PLANNING AMENDMENT

APPLICANT NAME AND ADDRESS South Holland District Council Priory Road Spalding Lincs PE11 2XE Telephone:		AGENT NAME AND ADDRESS S Greenfield South Holland Building Consultancy Council Offices Priory Road Spalding PE11 2XE Telephone:	
SITE ADDRESS DETAILS 13 Station Road, Moulton			
CURRENT APPLICATION NO: This amendment cannot be considered unless the relevant reference is stated.		H13-0120-20	
Building Regulation reference relating to same development (if applicable)

1 **Dropped Kerb - (Proposed)**
1 : 50

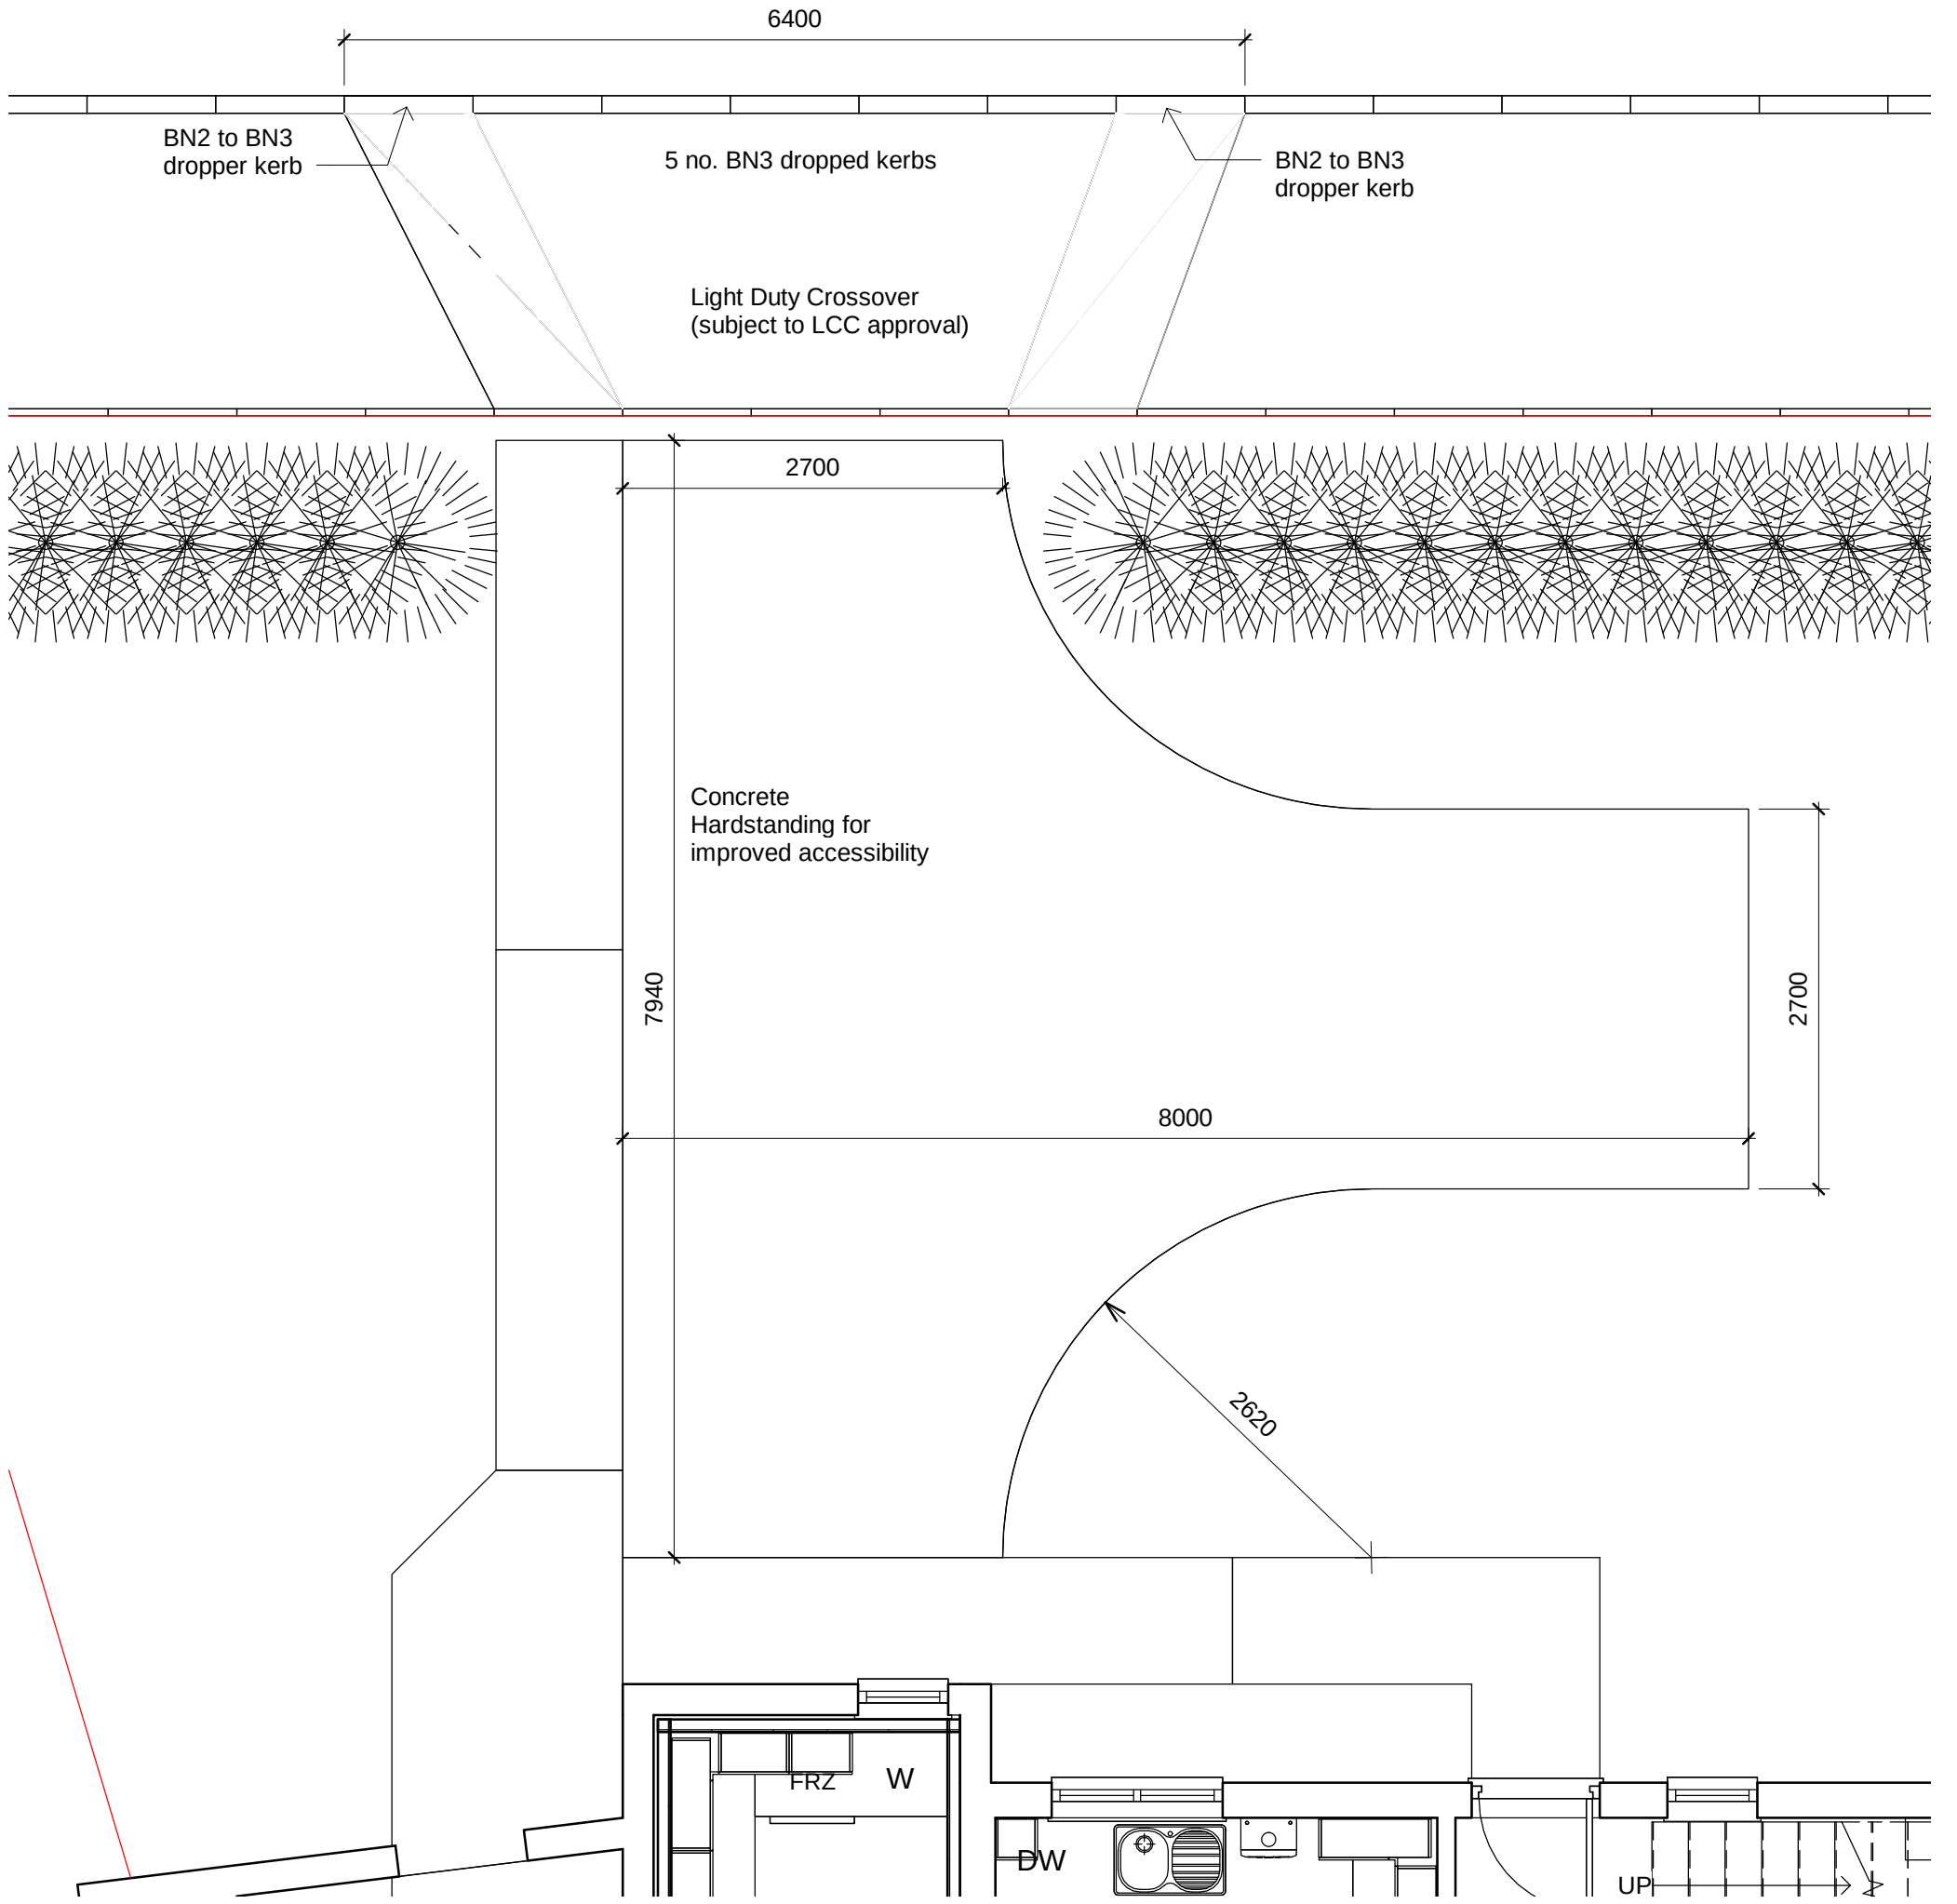
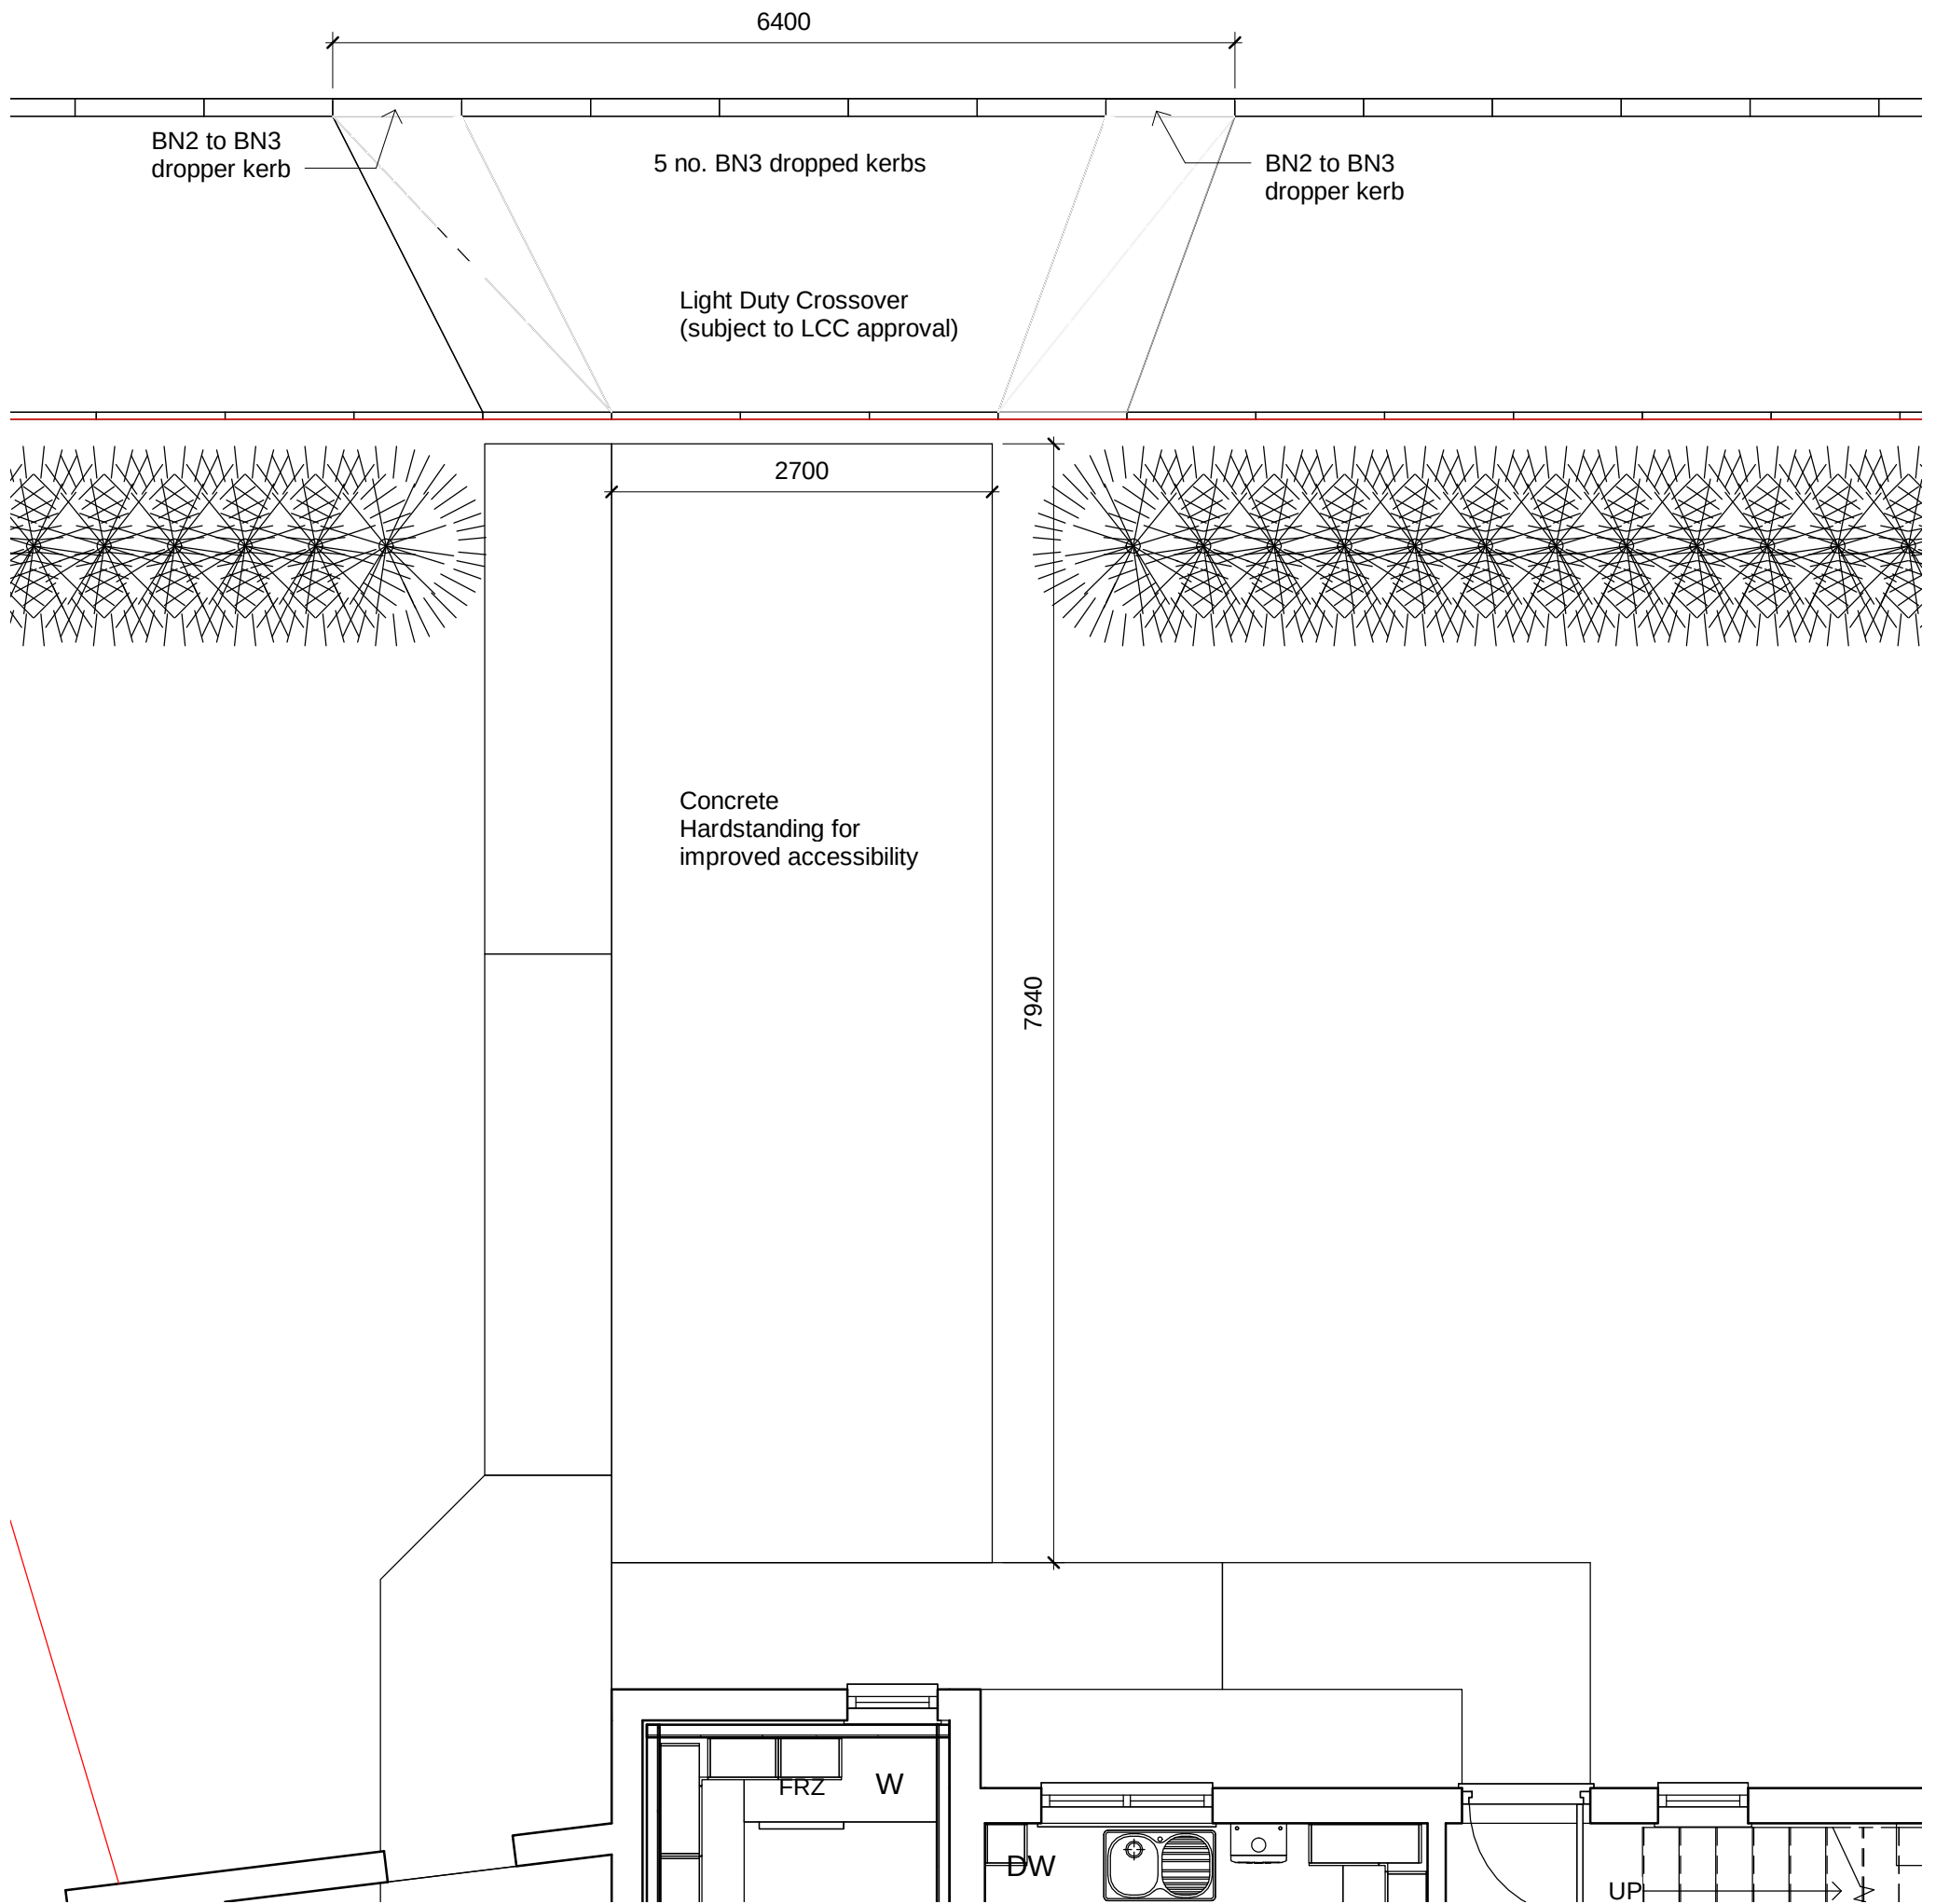
FULL DESCRIPTION OF DEVELOPMENT OF CURRENT APPLICATION THAT THIS AMENDMENT RELATES TO			
State details of amendments proposed. (Give a full detailed list of the changes, and also mark these clearly on the accompanying plans. Only the changes listed here will be considered)		Turning head added within dwelling curtilage	
State drawing numbers of the current submission		103A; 105A	
Has this amendment been requested by the Council? (If so, state Officer dealing with the application)		YES/NO	Maria Salemme
Describe any part of the original development which is excluded by virtue of the amendment, and state any alteration to plot numbers			
Has a similar amendment been submitted under Building Regulations? (If so, state Building Control Surveyor dealing with application)		YES/NO
